**KIRKLEES METROPOLITAN COUNCIL
INVESTMENT & REGENERATION SERVICE**

**DELEGATED DECISION FOR APPLICATION FOR CERTIFICATE OF
LAWFUL DEVELOPMENT**

Reference no.: 2021/CL/91443/E

Site: Primrose Farm, Crossley Lane, Mirfield, WF14
ONR

Proposed Extension

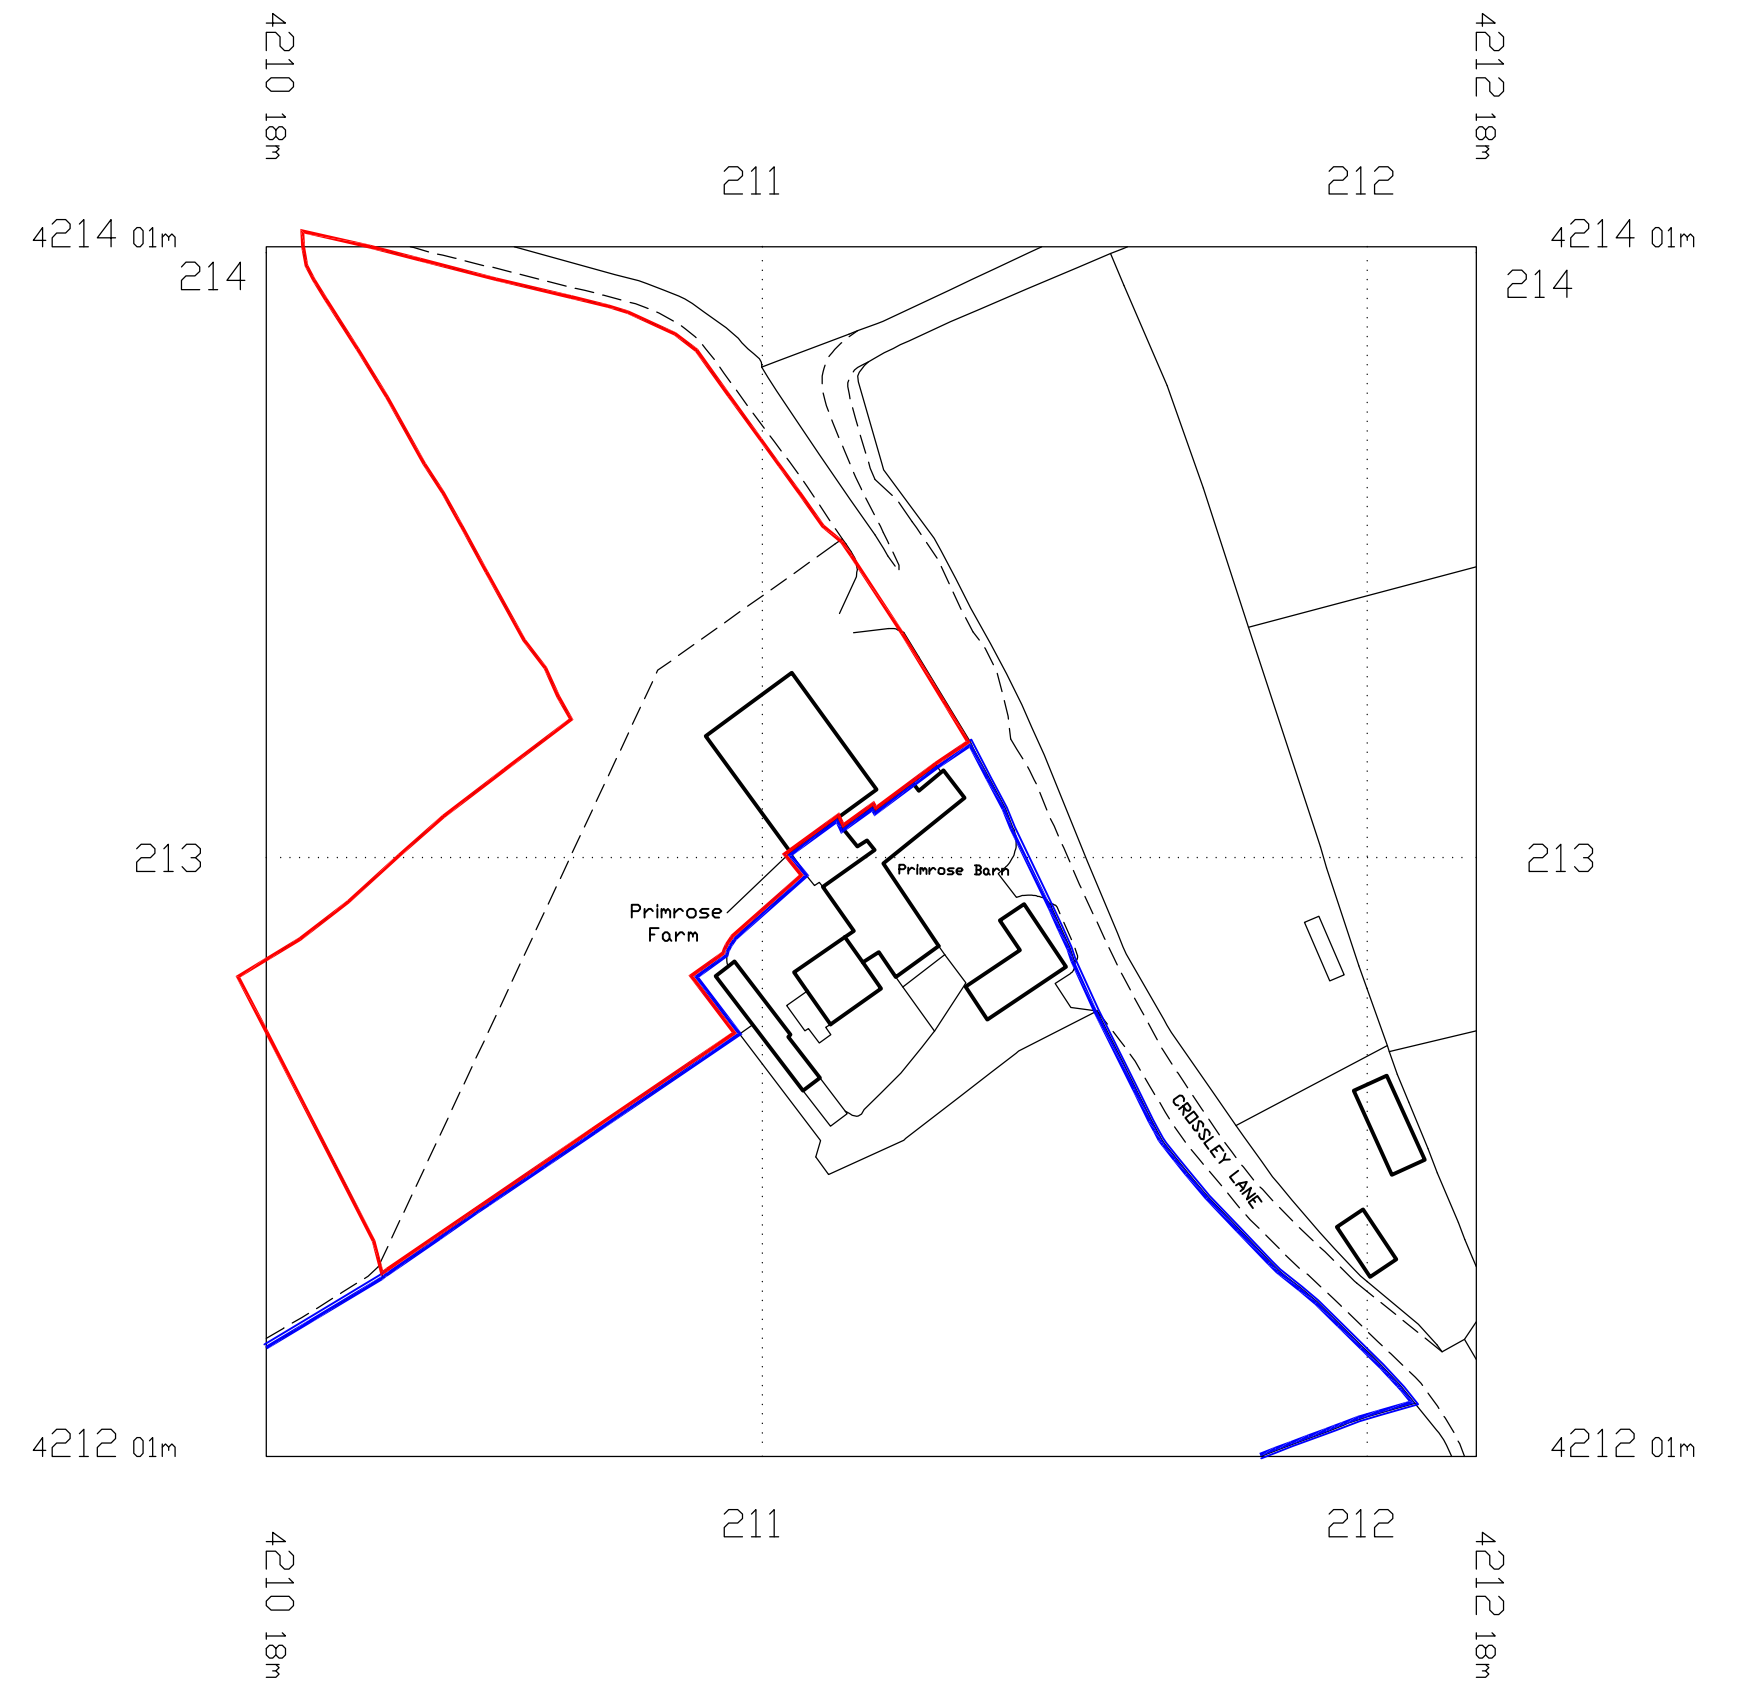
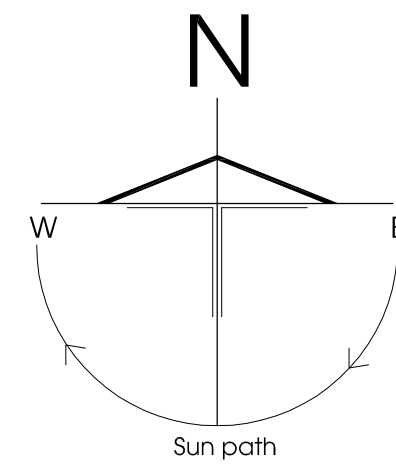
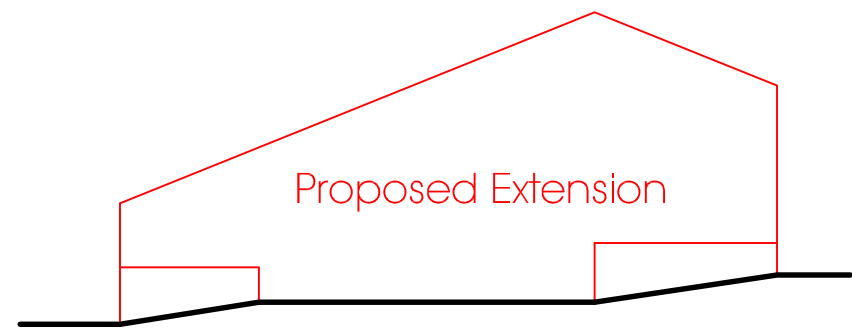
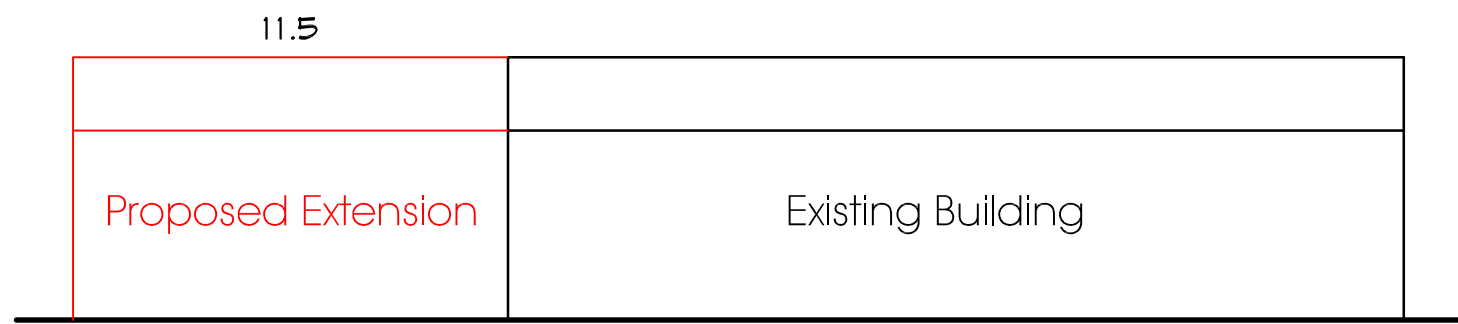
Having regard to this the extension would be sited within 5 metres of the curtilage of the premises contrary to paragraph (e) , Class F, Part 7 of Schedule 2 of the Town and Country Planning (General Permitted Development)(England) Order 20125 (as amended). Additionally, it would take up land that is currently used for the parking and turning of vehicles contrary to paragraph (f) of the same Order.

For the record, even if the building was still in use as offices, or used for industrial purposes falling within part (iii) of class E(g) of the Use Classes Order, the extension would still not meet all of the criteria it would need to meet to constitute 'permitted development' as an 'office' extension under Class A, Part 7 of the GPDO. This is because it would be within 2 metres of the curtilage boundary and the gross floor area of the original building would exceed 100 square metres contrary to paragraphs (a) and (c) of Class A, Part 7.

In any event the extension would also fail to fully meet the criteria for such industrial extensions as set out within Class H, Part 7 of Schedule Two of the Town and Country Planning (General Permitted Development)(England) Order 2015 (as amended). This is because of its proposed position in relation to the currently recognised boundary of the curtilage and because it would take up land that is currently used for the parking and turning of vehicles. The extension would constitute 'development' as defined by Section 55 of the Town and Country Planning Act 1990. Under the provisions of Section 57 of the same Act and in the absence of any planning permission the proposed development would not be lawful for the purposes of planning control.
